CM/45/19/PL

The site subject to this application comprises two barns which, whilst not statutorily listed, have been identified as a non-designated heritage asset by the authority. I note that a previous application on the site was granted permission in 2018.

The current application relates to a number of amendments to that previously approved scheme. These changes are both internal and external.

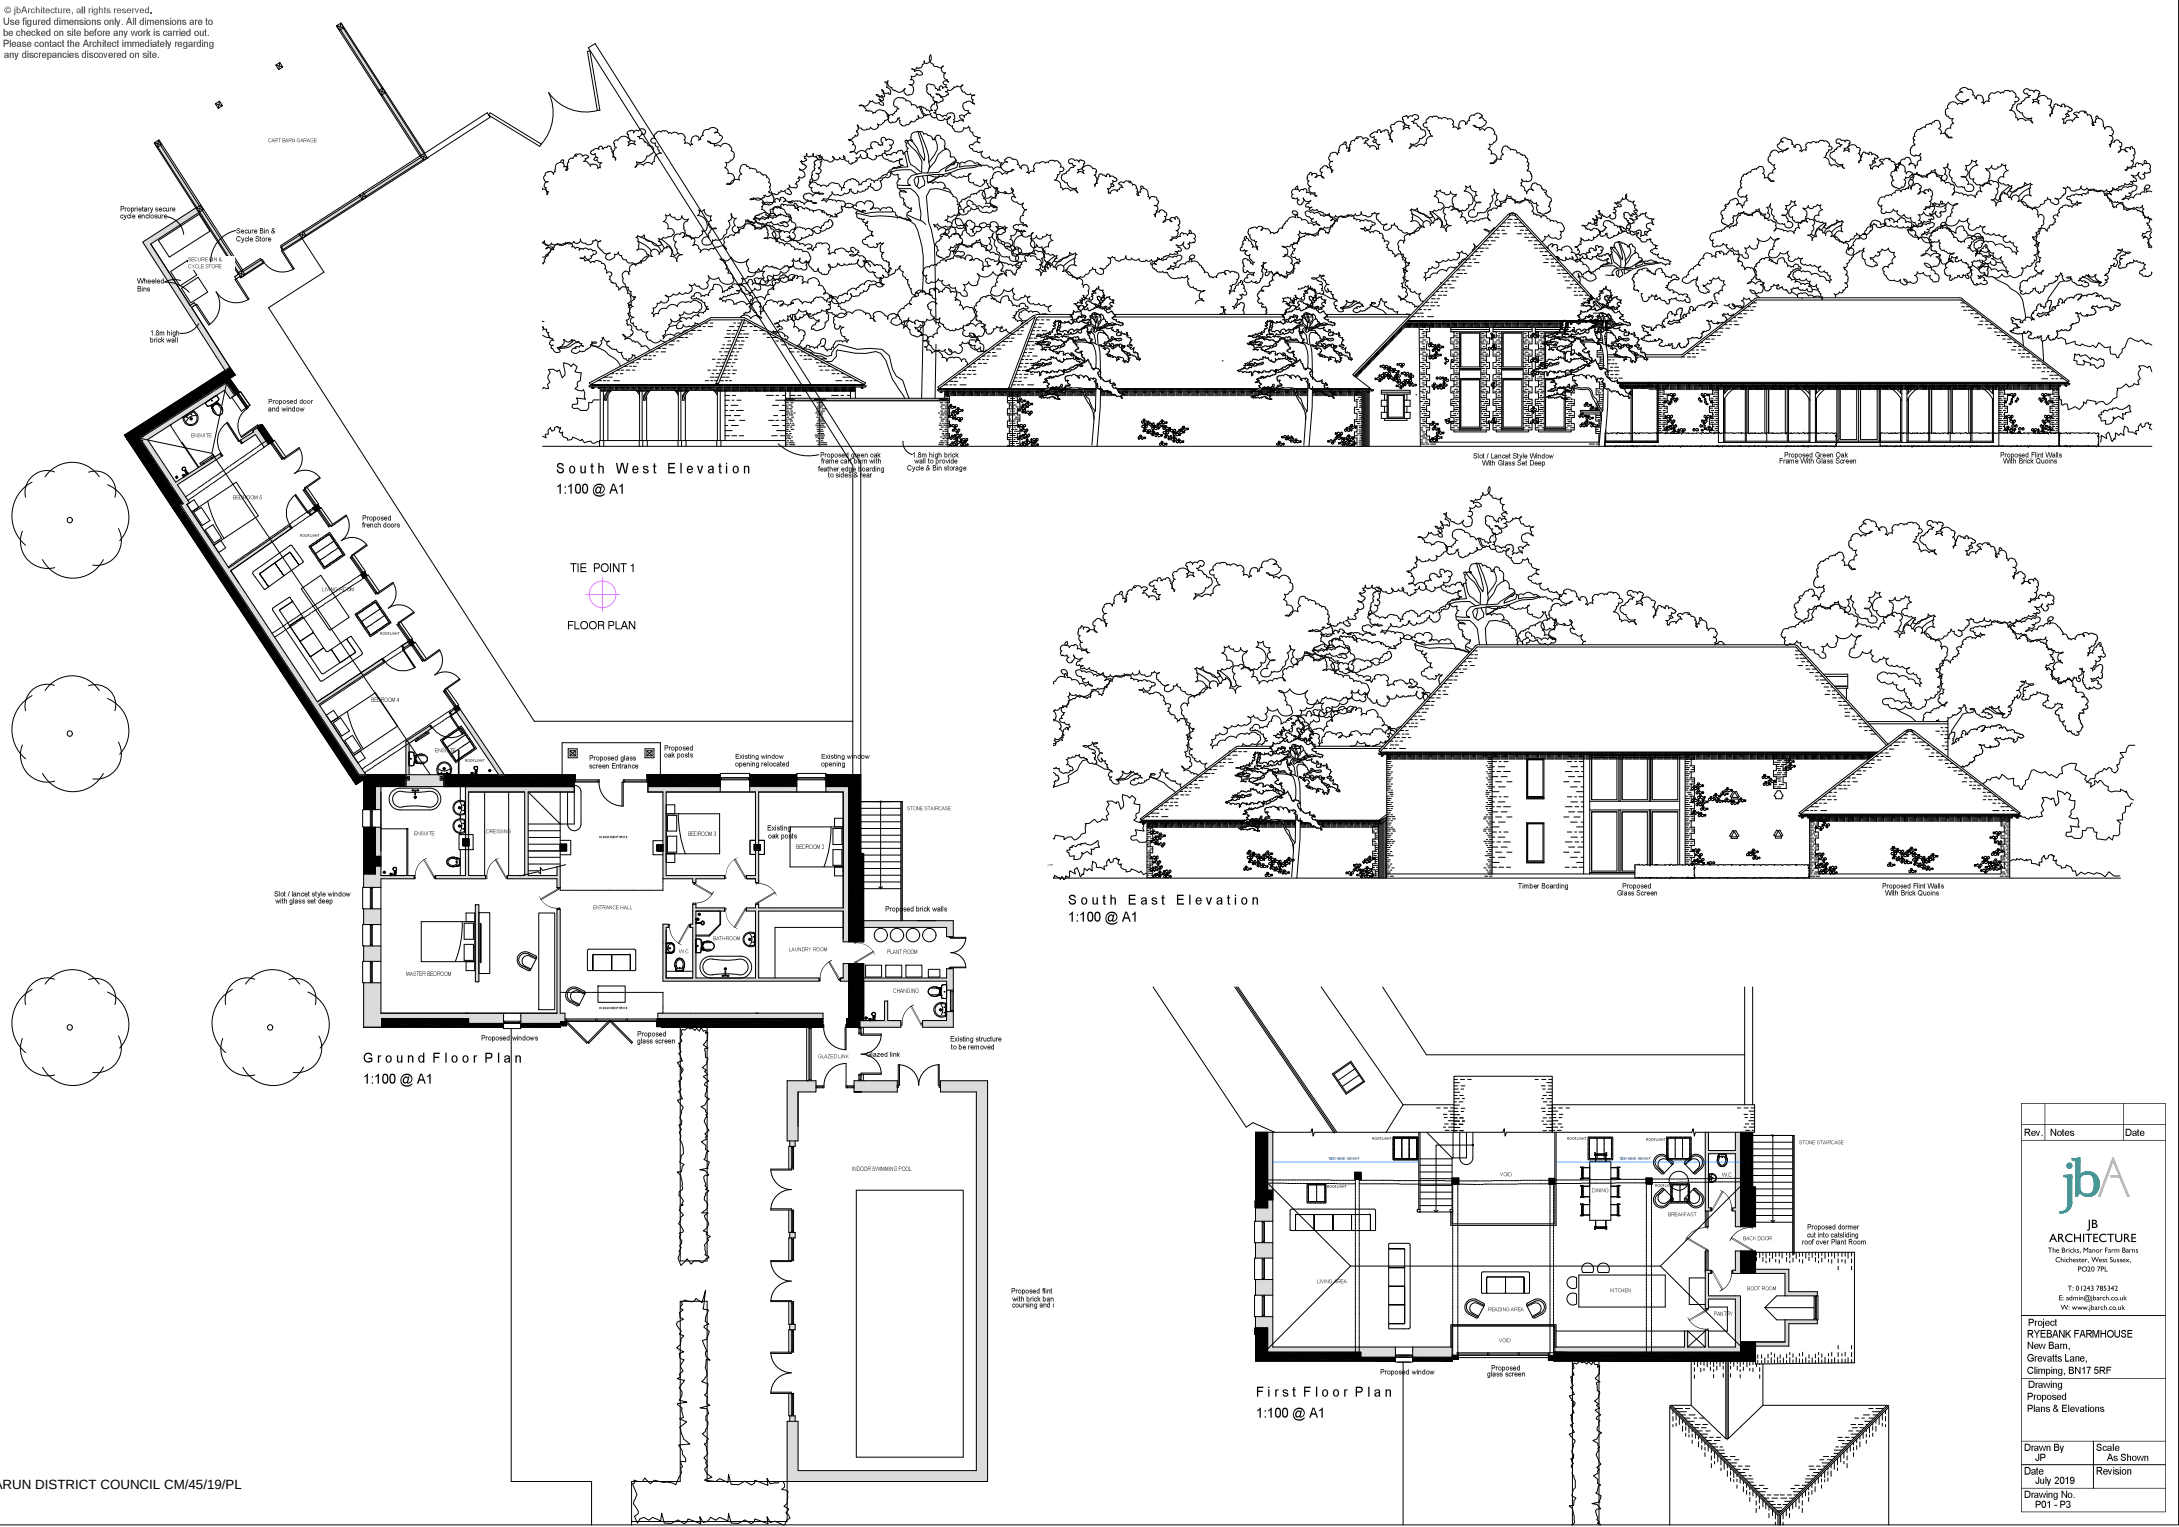
Internally, the previously permitted Kitchen/ Living spaces and Bedroom accommodation is relocated from the ground floor to the first floor. This opens up the entire first floor area, and results in a limited number of additional partitions being inserted in the previously proposed kitchen area. Such a proposal is considered to better accord with the guidance prepared by Historic England, and therefore considered to be acceptable.

Likewise, the introduction of a traditional brick and flint granary stairs to create a back entrance to the proposed first floor Kitchen and Living would not harm the character of the building. It is therefore considered to be acceptable. If minded to approve the application, you may wish to request details of the railings and the flint/brickwork in order to ensure that they are appropriate for the building.
